SPR EA1N and EA2 PROJECTS

DEADLINE 13 – COMMENTS ON DEADLINE 12 FLOOD RISK RELATED SUBMISSIONS

Interested Party: SASES PINS Refs: 20024106 & 20024110

Date: 5 July 2021

Appendix 5: Indicative Attenuation SuDS Basin Figures

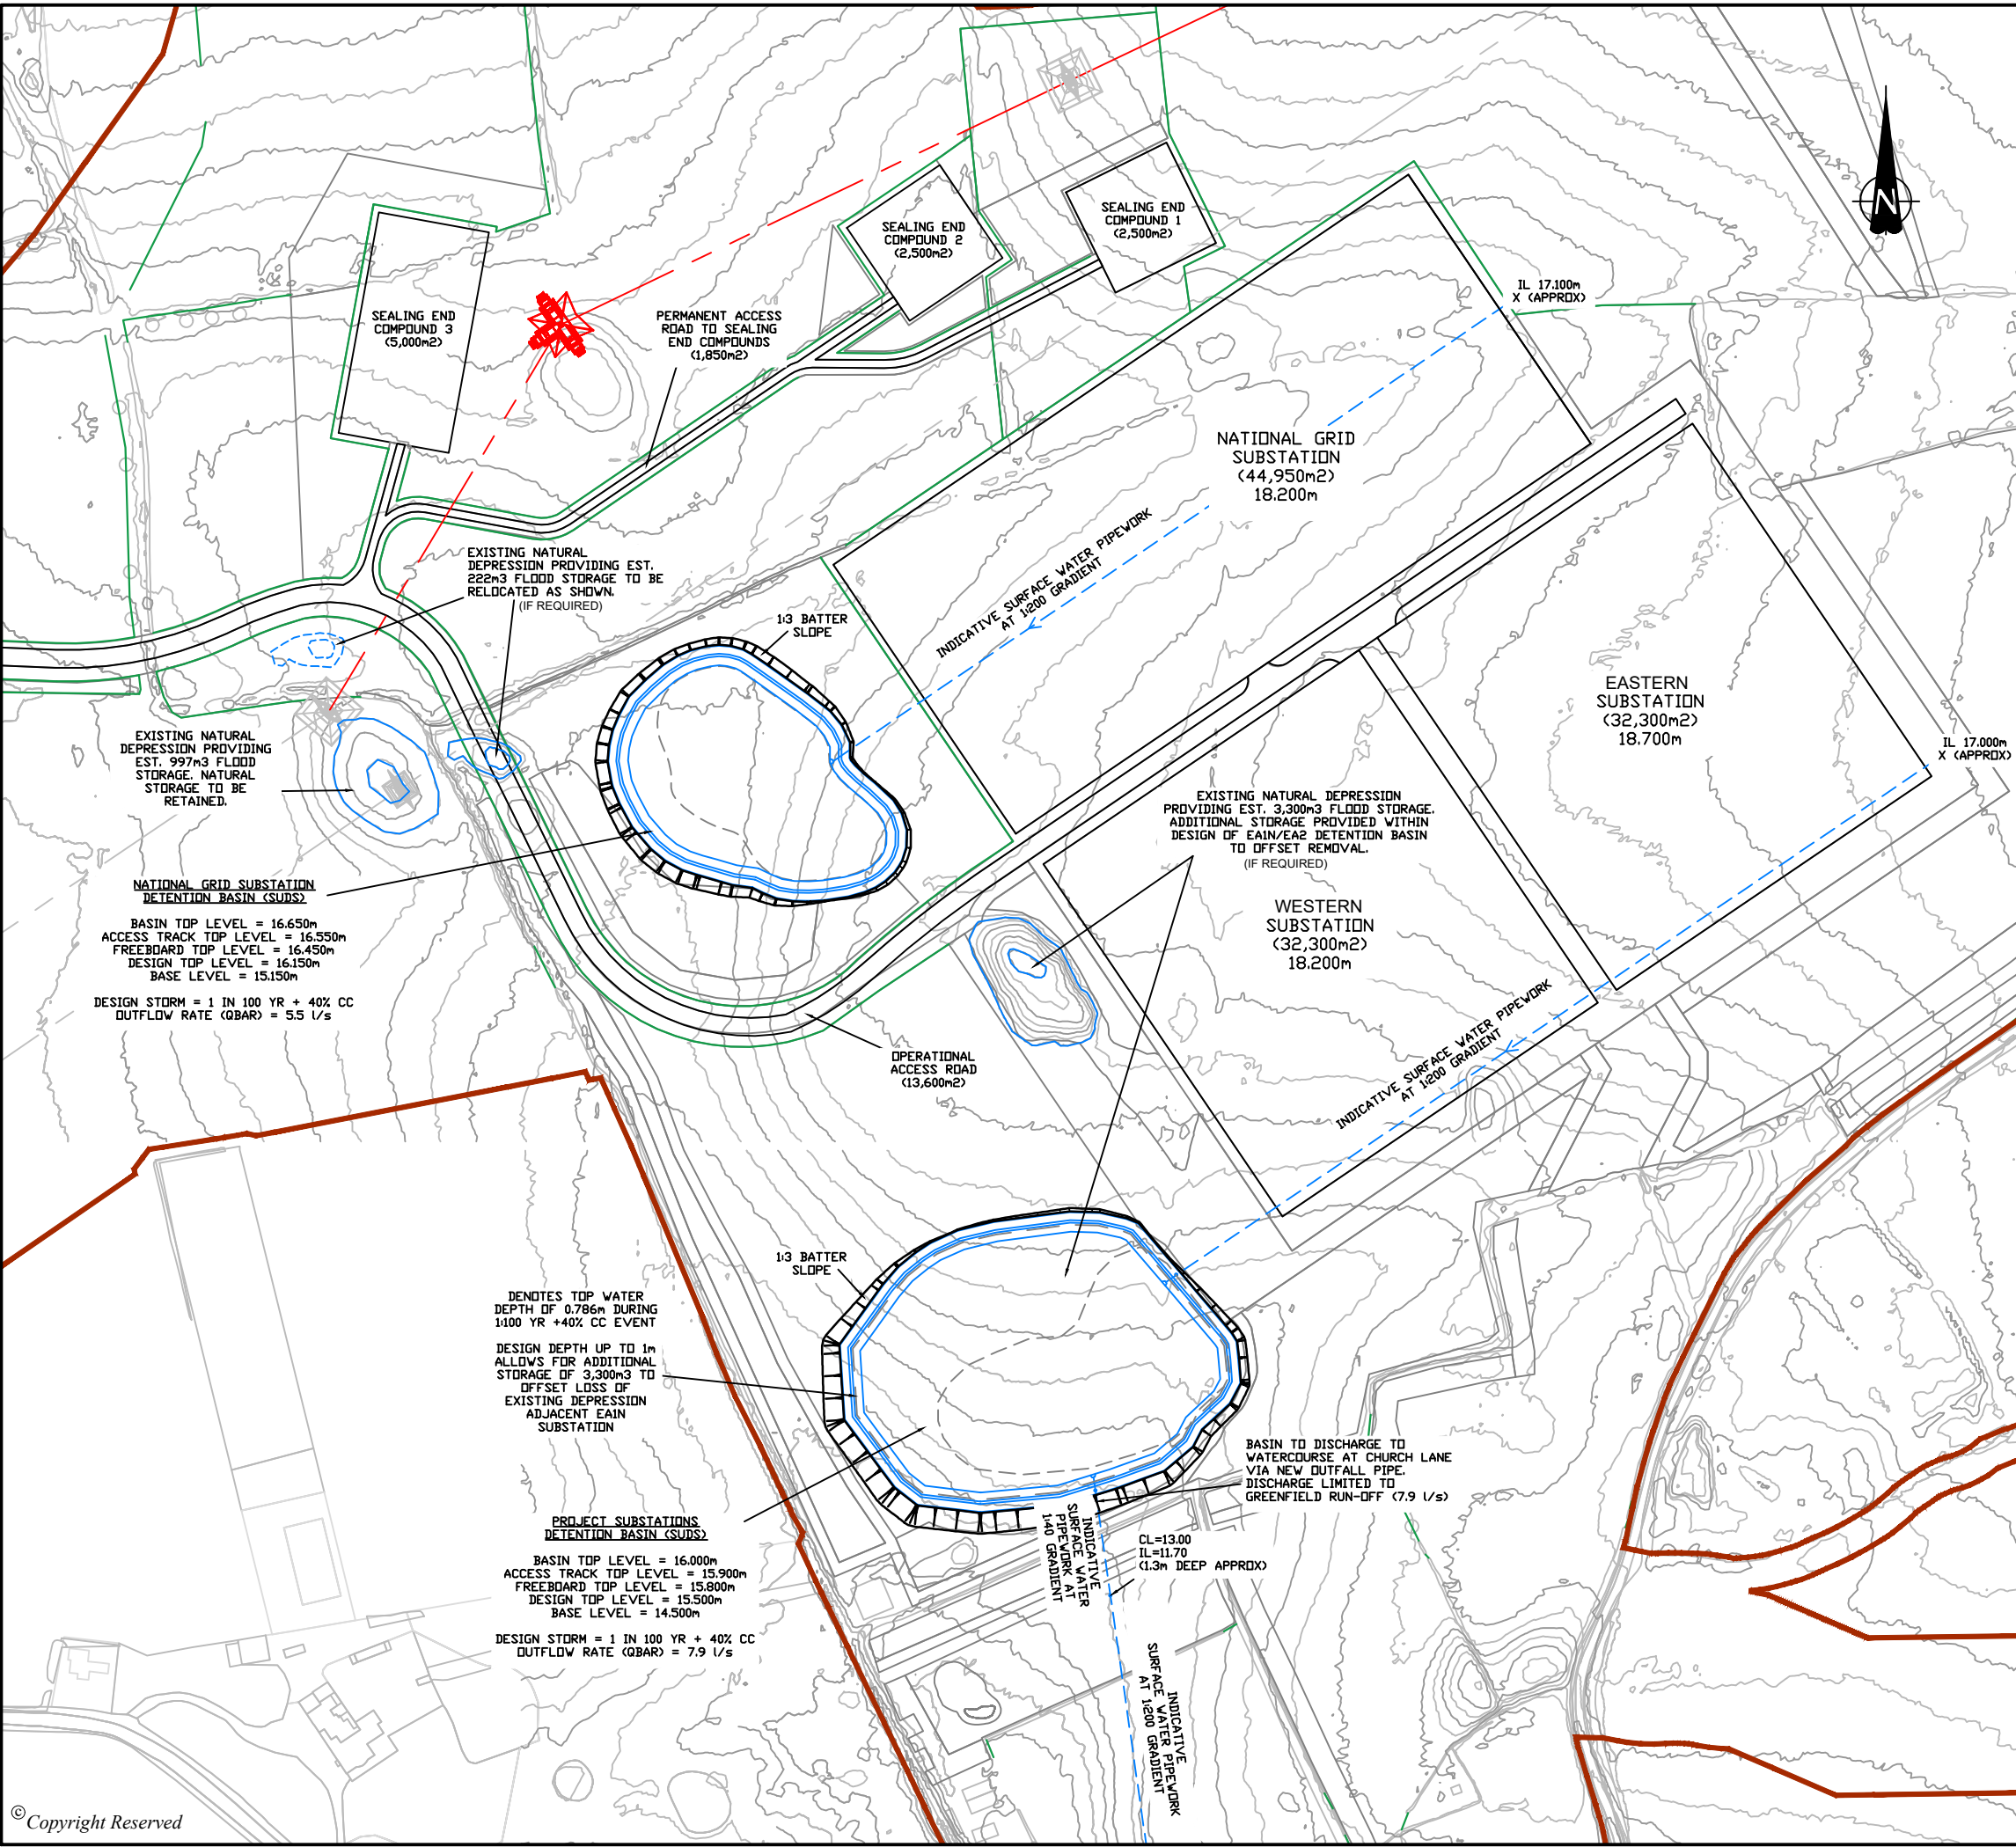
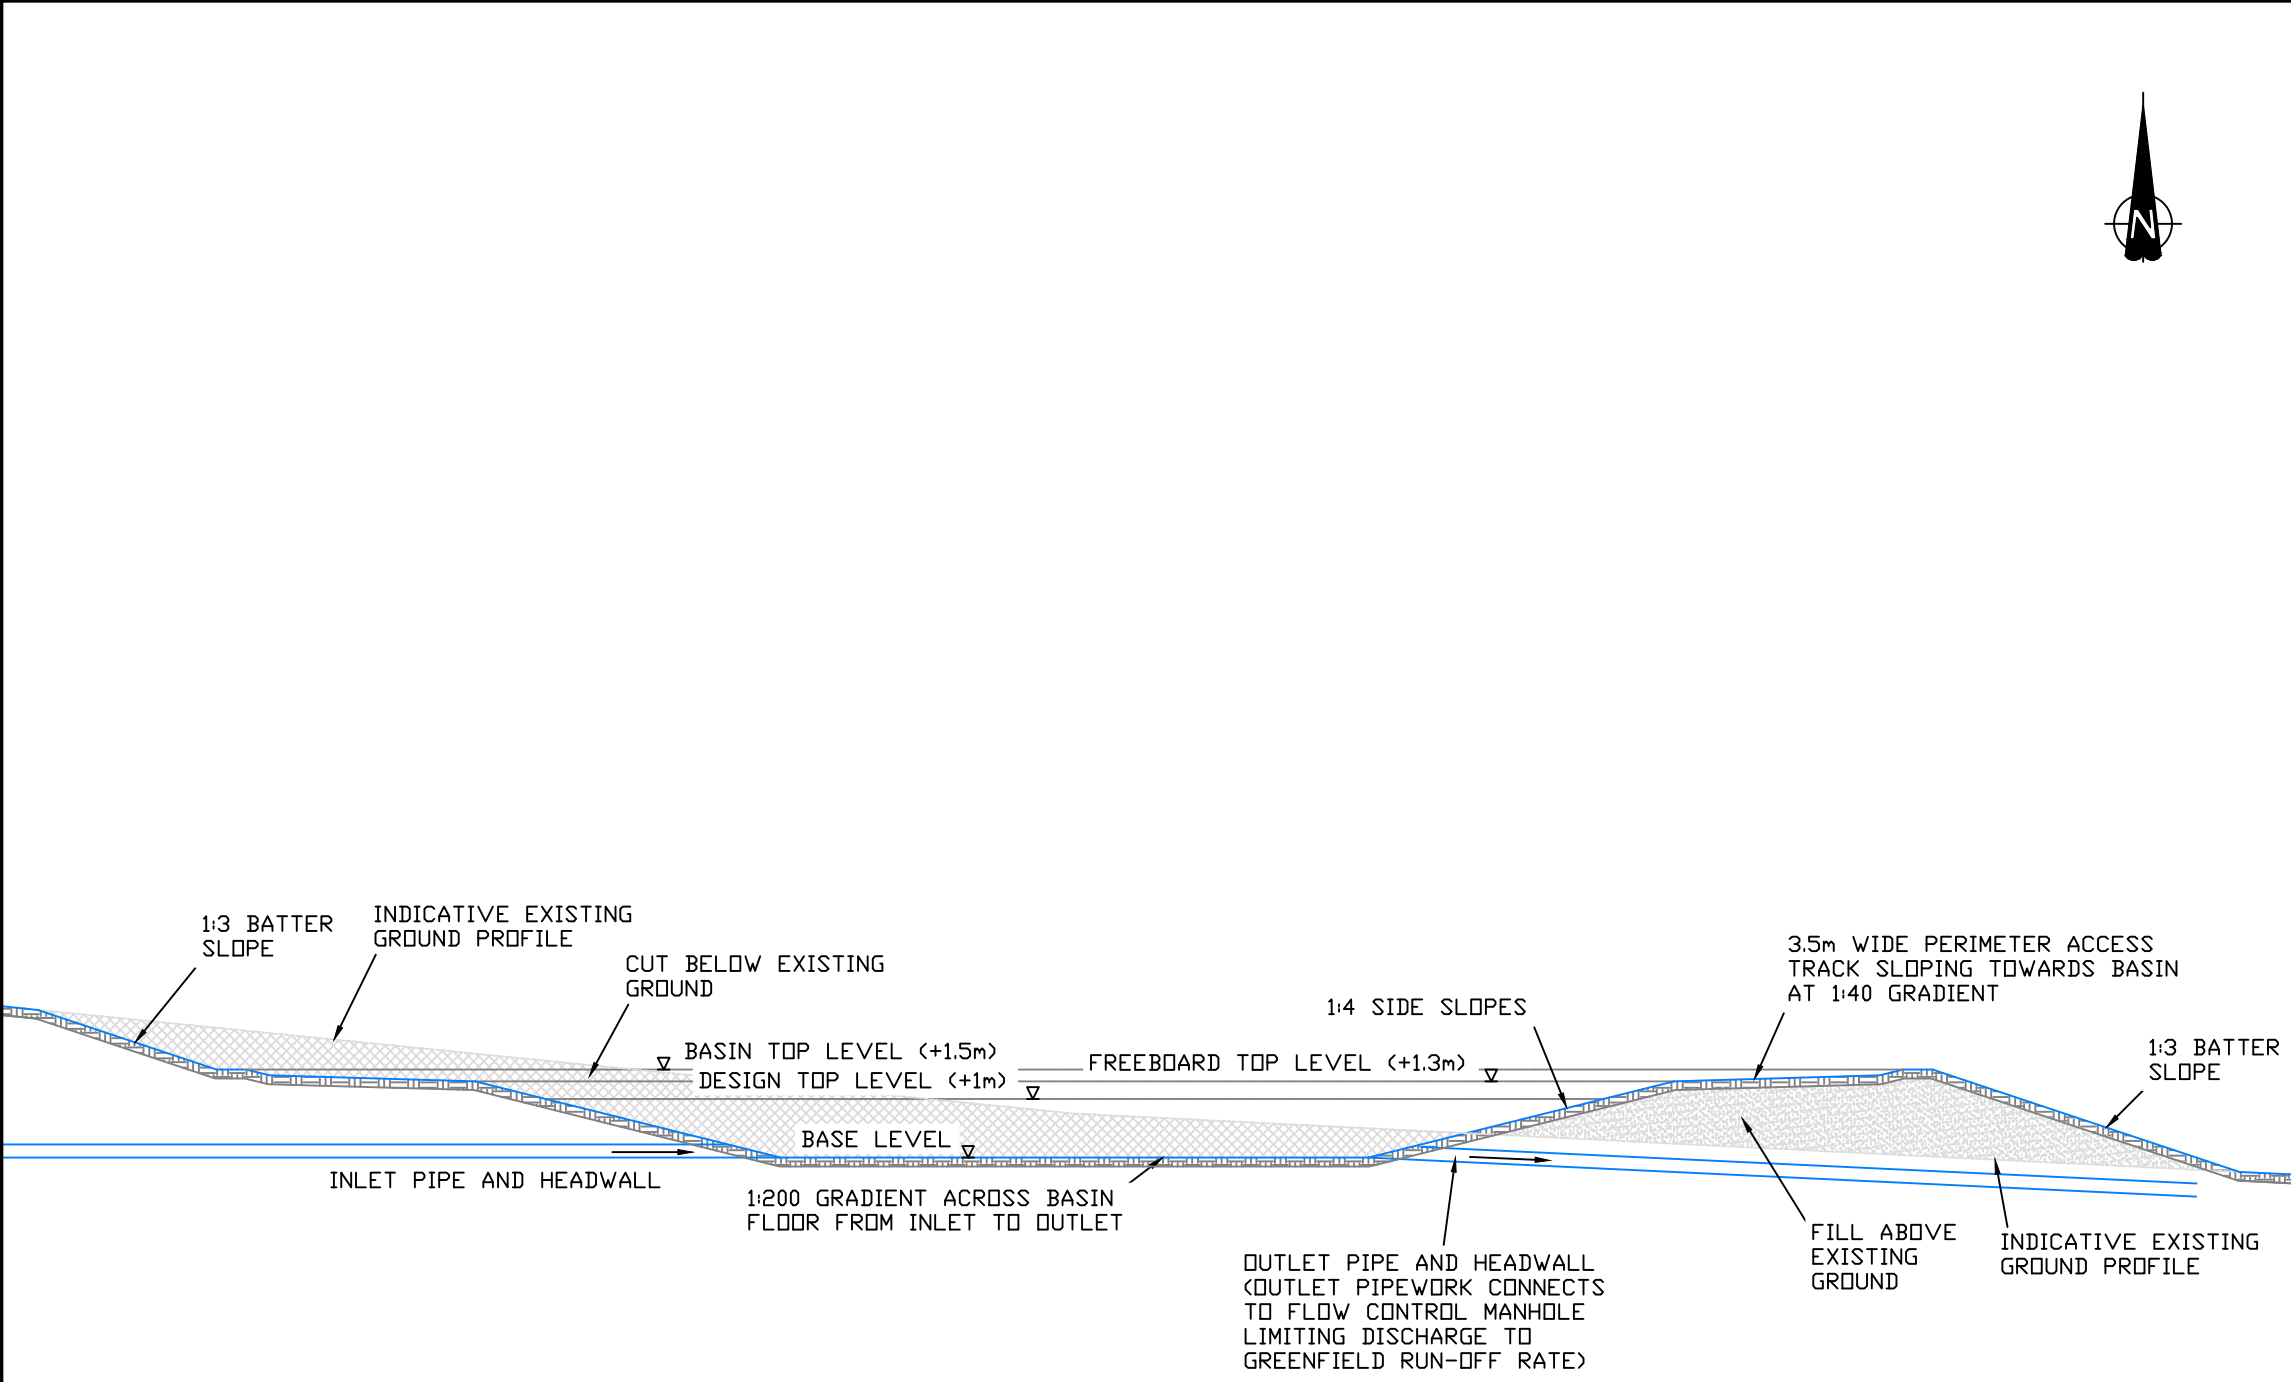
GWP reiterates previous concerns that i) QBAR has not been adequately defined and ii) 1 in 2 Year storms do flood the village and hence restricting flows to QBAR does not ensure flood risk increase is prevented.

nor the flood risk receptors, nor the groundwater flood risk. As such any drainage options which utilize a QBAR – which both basins do in the current design – are therefore fundamentally flawed as the assumption made is the QBAR is both accurate and does not cause flooding. The QBAR is however poorly defined and has not been proven to not cause flood risk.

GWP states that this demonstrates the soft engineering approach being taken by the Applicant to contain storm water of 10,000's m3 immediately above a residential village, despite the risk to life from failure of these basins to be proximal to that regulated by the Reservoir Act. Water retention structures of this volume need to be properly engineered and maintained and not constructed of landscaped materials, with no allowance for controlled over-topping and erosion prevention. This landscaping approach to flood water retention is inappropriate in any location but especially a few 100m uphill of a residential village.

21. **ID10** - Overflow structures need to be properly engineered as they will contain 10,000 m³ of water immediately upstream of a residential village. Landscaped earthworks which will erode are unacceptable. This needs to be expressly referred to in the OODMP and the OLEMS.
